SSD 14_6746 - 2-14 BUCKLAND STREET CHIPPENDALE NSW

I have reviewed the Environmental Impact Statement (EIS) for a proposed use and maximum envelope (including height and floor space) for a six storey educational establishment over a site area of 6,043sqm, and wish to object to this proposal.

Fig. 7. UTS Blackfriars Research Facility Section of Envelope

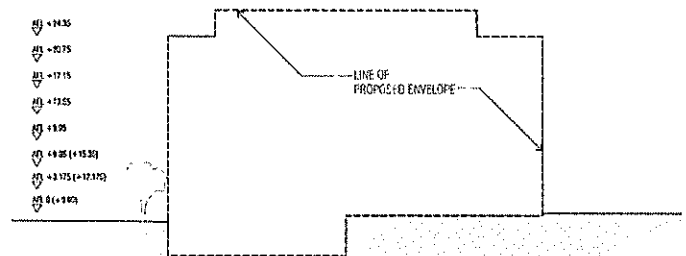
In addition, the massing, bulk and height of the proposal does not appear to respect the form, height and urban grain of the existing heritage values of the area, or have any regard to the statutory height controls (being a maximum of 9m in this case) established specifically for this significant listed heritage precinct.

The proposal is unsympathetic to the heritage values of the site and the area. It is necessary that a maximum building height of 9m be applied to the site in accordance with the statutory maximum height applicable to the site under Sydney LEP 2012.

As the Table 1 shows, the proposed building height breaches the local height limit by 18.95m (LEP height limit is 9m) (Table 1). This proposed height is excessive, inappropriate, overbearing and is not congruent with the local statutory development standards established specifically for a listed heritage precinct.

We suggest a sensitive infill development which respects the heritage values of the site and the area is considered. Indeed, a 9m high future development that responds to the existing urban grain of the site on a smaller floor plate would be more appropriate to the site and its context.

Fig. 8. UTS Blackfriars Research Facility Plan of Envelope

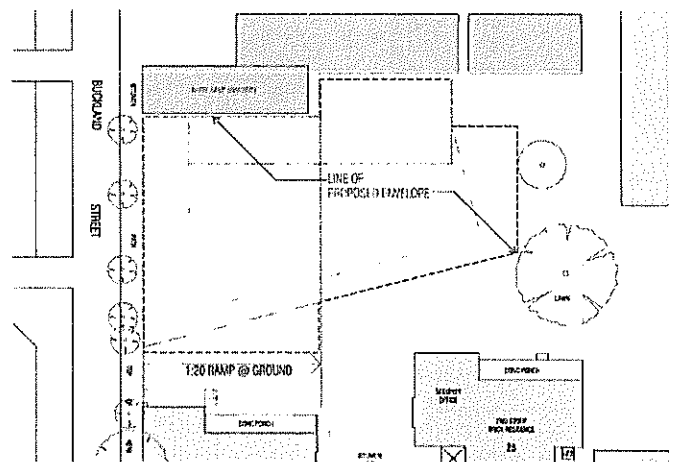
The UTS building envelope includes a zero setback to the north along University of Notre Dame Australia's boundary. There is no urban design discussion or architectural justification for this approach in the submitted documentation which considers the existing or future development on the adjoining site to the north.

It is necessary that a minimum setback of 3 metres is to be provided to the common boundaries with UNDA and where there are to be glazing or openings in any elevation, a minimum recommended setback of 6m is to be provided.
